Submission No.			008	
Organisation Name or Name of Submitter			An Taisce	
Item No.	Section Ref.	Page No.	Observation Statement	TII Response
Letter Re: Railway Order Application- Metro North: Estuary through Swords, Dublin Airport, Ballymun, Glasnevin and City Centre to Charlemont, Co. Dublin				
1	1 Intro and Overarching Comments	1	We welcome the overall proposal as it is a long overdue strategic priority for the improvement and expansion of the public transport network in and around Dublin	TII welcome your support for the project.
2	1 Intro and Overarching Comments	1	The proposal needs to be integrated with a wider transportation initiative for the catchment area to reduce private car use and dependence, including the promotion of cycle-and-ride to use the Metrolink stations.	As detailed in Chapter 6 (MetroLink Operations and Maintenance), the proposed Project has been designed to ensure maximum interchange with other modes of transport, specifically other sustainable modes of transport such as walking, cycling and public transport. All operational stations will have pedestrian and cycle access, with bus stops located either adjacent to or within the site to facilitate integration

Drawing Title	METROLINK - STRUCTURES TARA STATION PLATFORM & UNDER PLATFORM LEVEL		Drawing Status	S0
Drawing N°	ML1-JAI-SRD-ROUT_XX-DR-Y-02081	Plan Drawing N°	ML-ST 306 O-A4	
Scales Original Size A1	1 : 250		Sheet 4 of 6

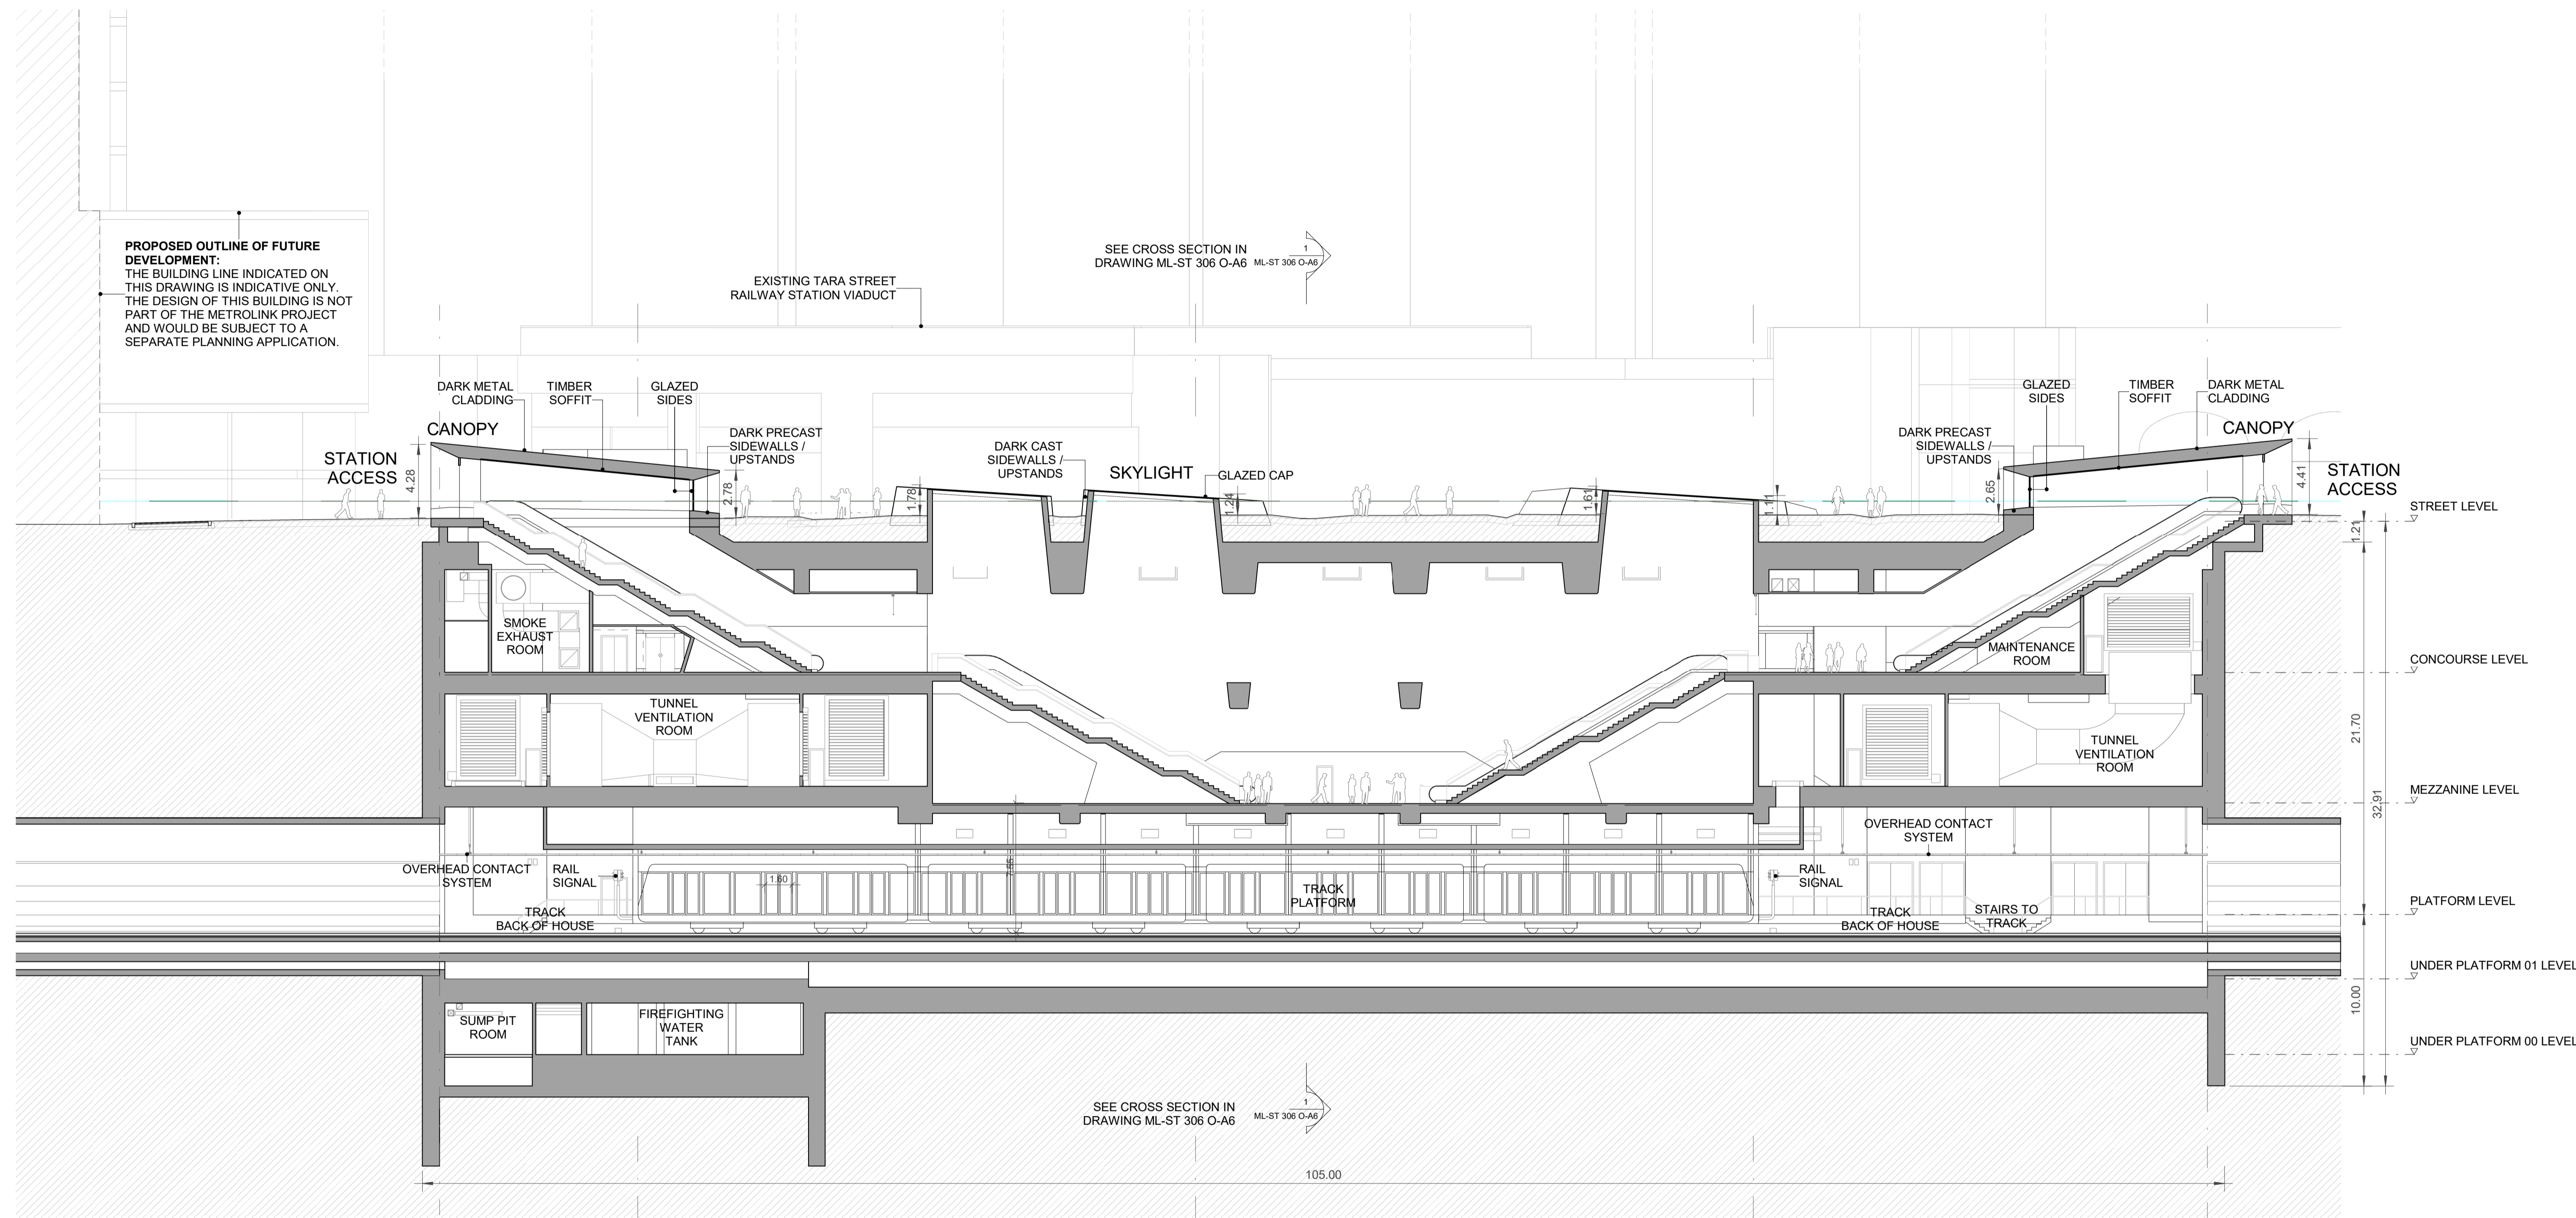
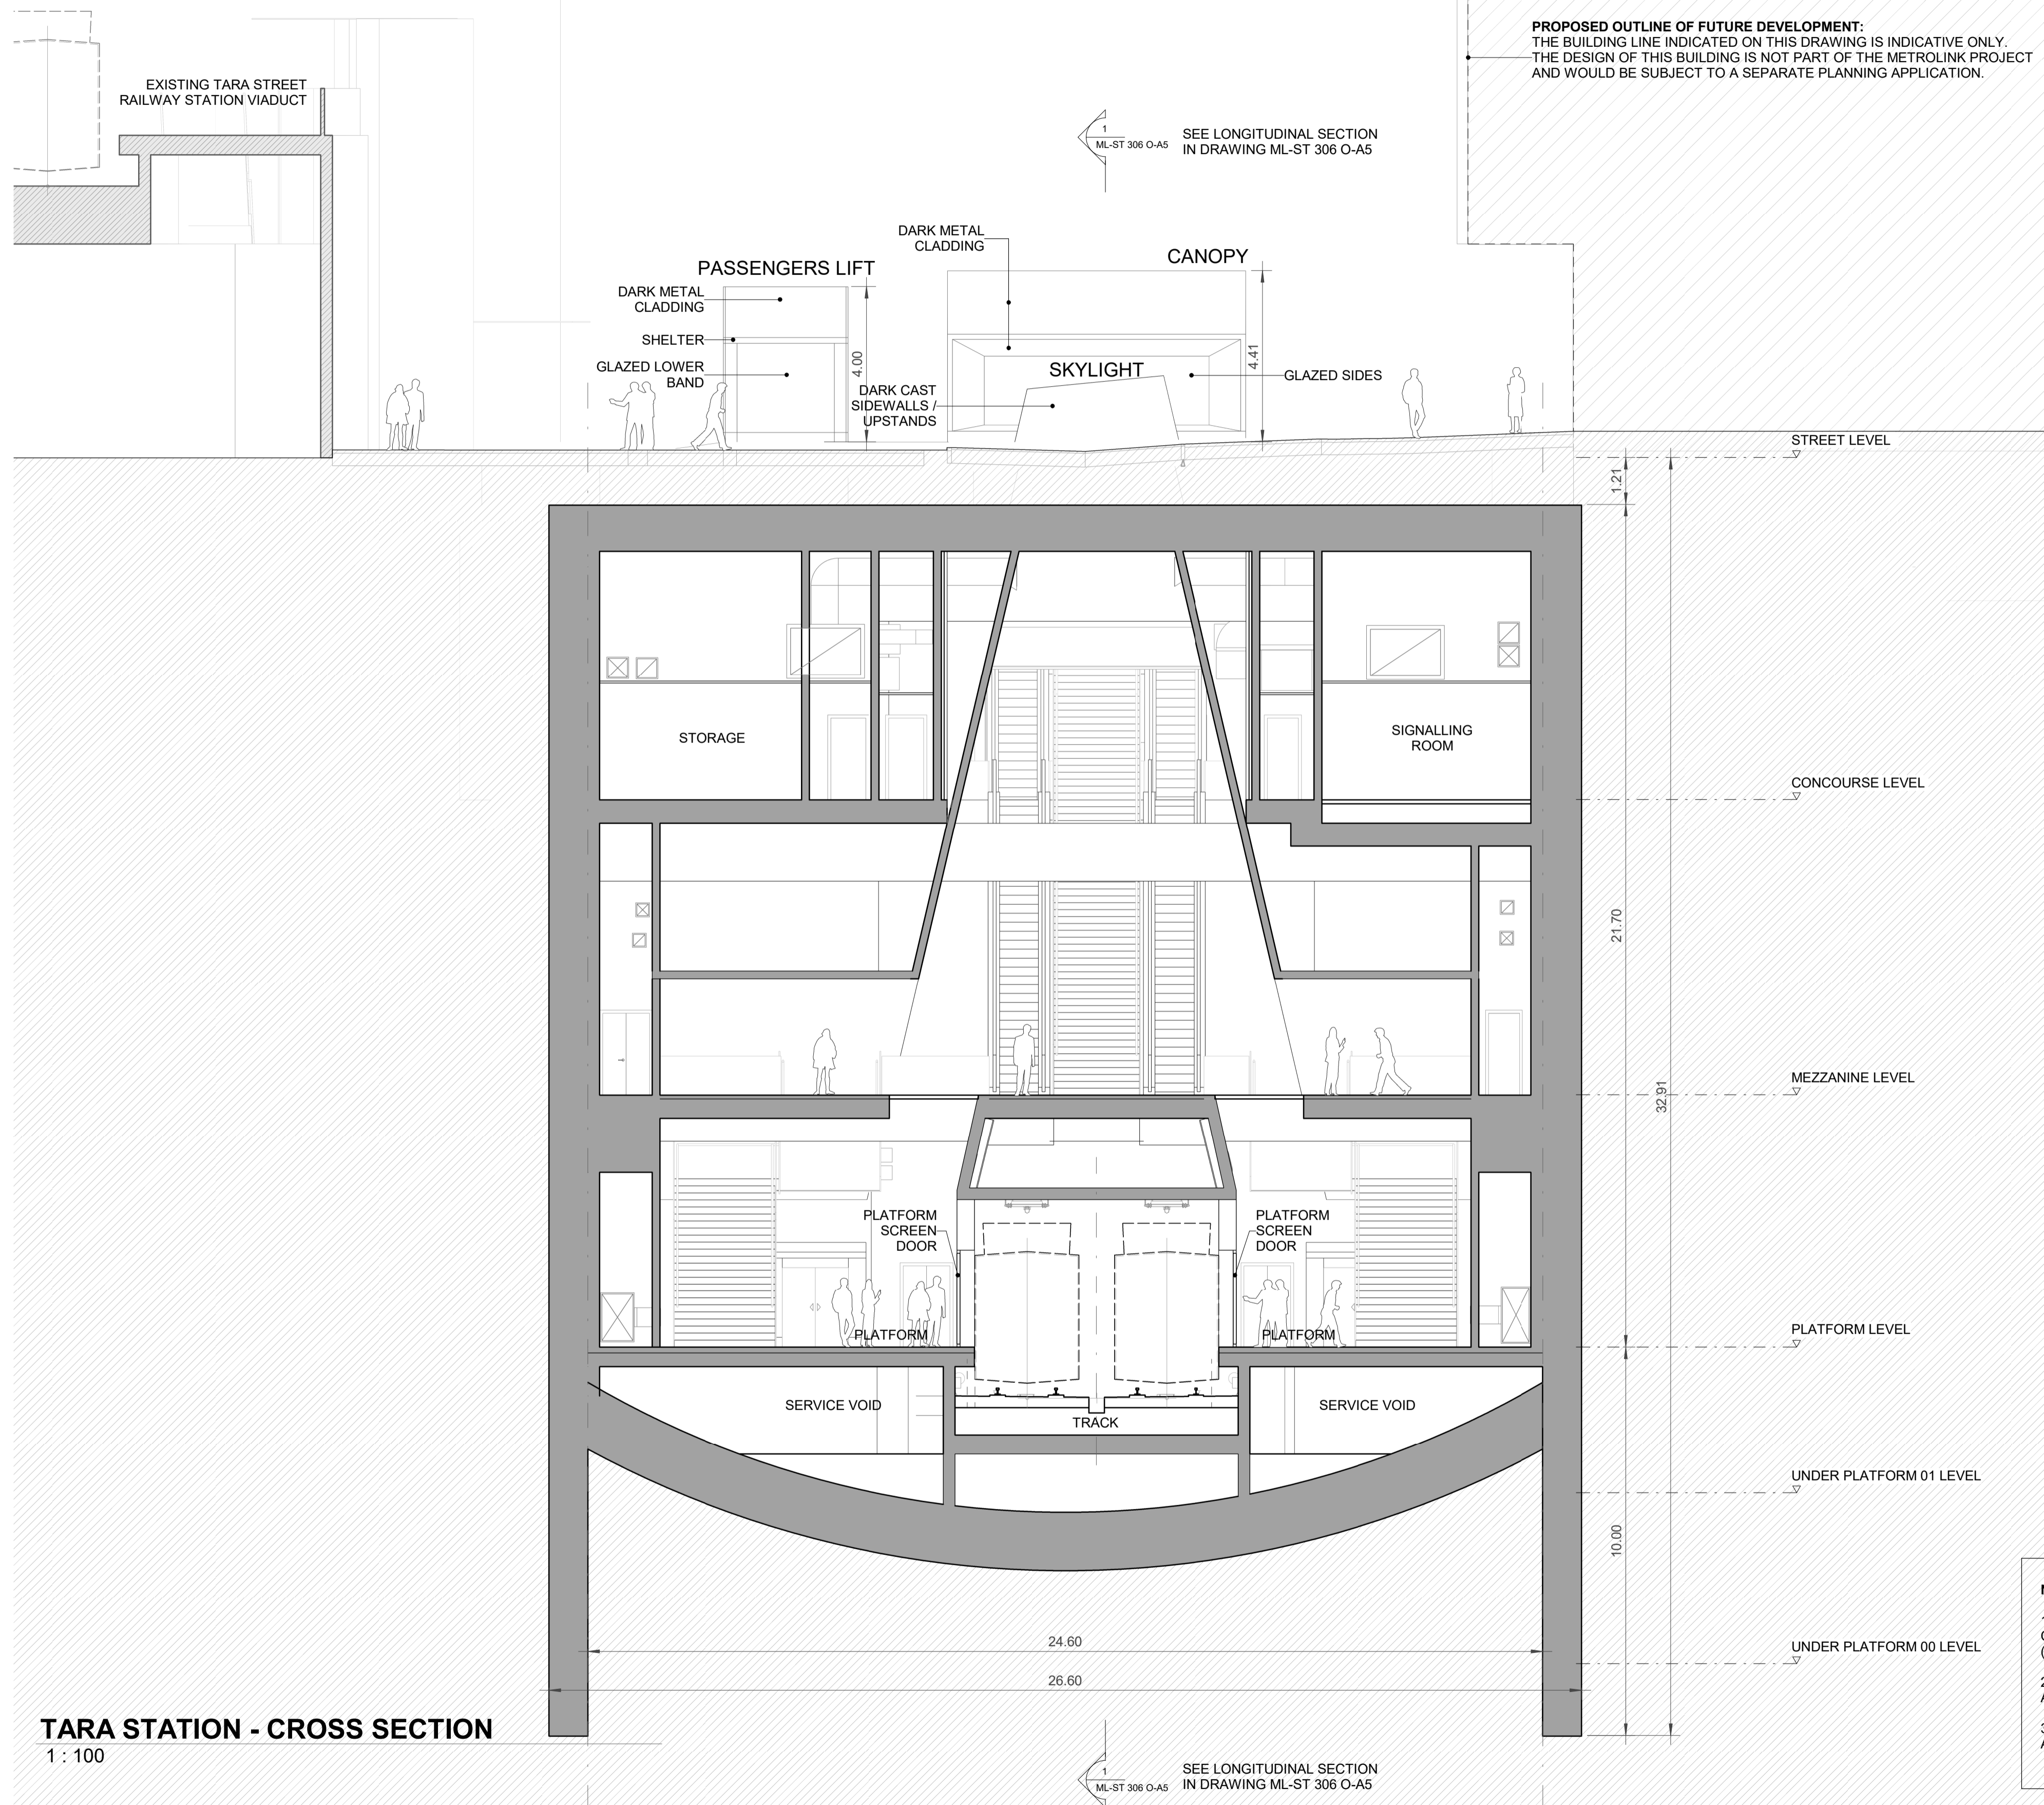
4	3 Alternatives to Demolition of the College Gate Building	3	We will now review the alternative designs for Tara Station, which were listed in the Preferred Route Design Development Report (PRDDR),but were not recommended for a variety of engineering based constraints mentioned above, which we recommend be reviewed by the Board. These are a modified version of Option3 Station moved southwards, which we suggest be considered if constructed as per option 4, to mitigate the major concerns outlined in the PRDDR.	Please note that the Option 3a as discussed in the EIAR is a modified version of Option 3 with mining as per Option 4 to eliminate the need to divert the Townsend sewer. The concept design for this option showed that there was insufficient clearance beneath the sewer to allow for the requisite station facilities and hence this option did not work. So, the suggested alternative has been assessed. This is clearly explained in Section 7.7.10.9.1 of EIAR Chapter 7. It is further noted that impacts on the Townsend sewer would remain. Please note the mining would be required to be undertaken 24/7 and hence result in similar impacts as Option 4 as discussed above in Item 5.

Submission No.			008		
Organisation Name or Name of Submitter			An Taisce		
Item No.	Section Ref.	Page No.	Observation Statement	TII Response	
Letter Re: Railway Order Application- Metro North: Estuary through Swords, Dublin Airport, Ballymun, Glasnevin and City Centre to Charlemont, Co. Dublin					
8	3.3 Option 3A. Suggested alternative to Option 3 (using impacts to the construction techniques of option 4)	6	By adopted same construction methodology of option 4 construction and the major disruption with the diverting of mains sewers, the closing of Townsend Street to traffic during construction and the building on Spring Garden Lane needing to be demolished could be mitigated. Also, as per options 0 and 4, Tara Station will act as a multi-modal interchange station between Metrolink and DART railway line. The main point of interchange between the two stations will be via the southern entrance to Tara Station, with MetroLink access remaining as per option 3. Although the same construction methodology of option 4 would involve mitigating similar engineering related constraints and risks as per this option, but as per our comments on option 4, these Project Risks and Constraints have been successfully mitigated on other underground metro stations, elsewhere, and we would therefore recommend that Option 3A be considered, as an alternative to Option 4, if An Bord Pleanála deem that the College Gate building should be retained.	Refer to Item 4.
